PLANNING CONSULTATION RESPONSE

Application No	<u>2026/0420</u>
Proposal	Erection of 10no. 2 and 3 storey detached dwellings
Address	Land west of Sheffield Road, Birdwell, Barnsley
Date of Consultation Reply	11/08/26
Consultee	Highways Development Control

LOCATION PLAN
SCALE 1:1250

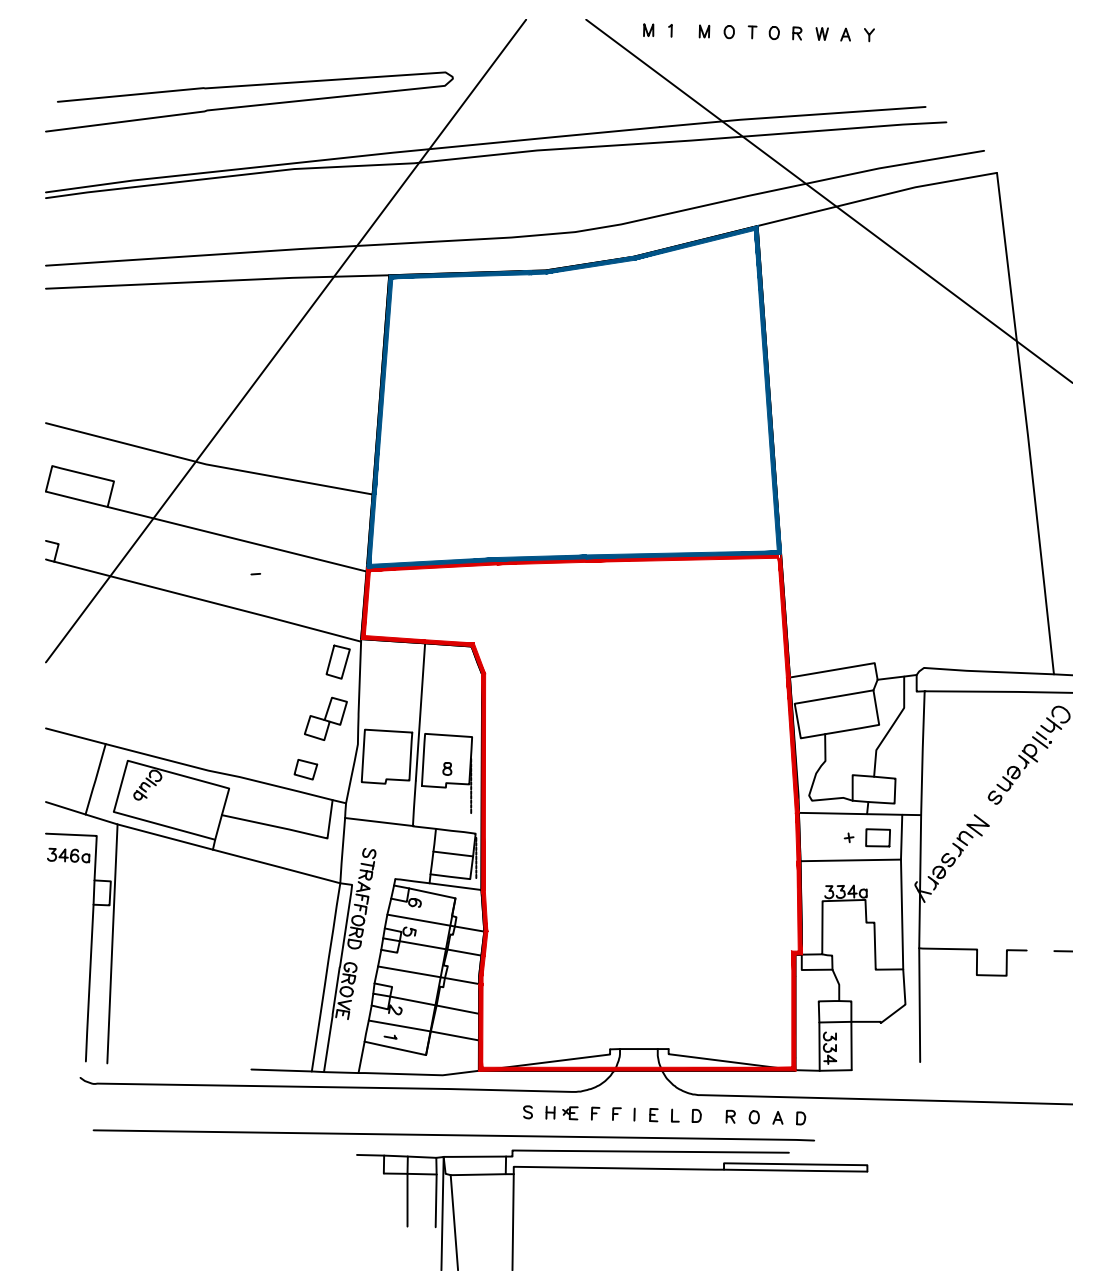
The existing access has a wide and open frontage onto Sheffield Road and the required minimum visibility of 2.4m x 43m can be achieved. Whilst The parking provision meets the minimum requirements as set out in Barnsley's parking SPD however I would highlight that plots 5 to 10 are reliant upon the integral garage as part of the required parking provision, however, this measures approximately 3.5m x 6.5m and is considered suitably sized for this purpose. I note however, that there is no allocated visitor parking within the site and would expect at least 2 spaces for a site of this size.

The site appears to fall significantly away from Sheffield Road and, whilst the submitted engineering drawing provides details of proposed levels, further information is required to demonstrate that suitable gradients and transitions can be achieved along the internal access and to the individual driveways, particularly given the change in levels through the site.

If further information could be provided in terms of the gradients within the site and the concern with the lack of visitor parking addressed, I will be happy to reassess the application.
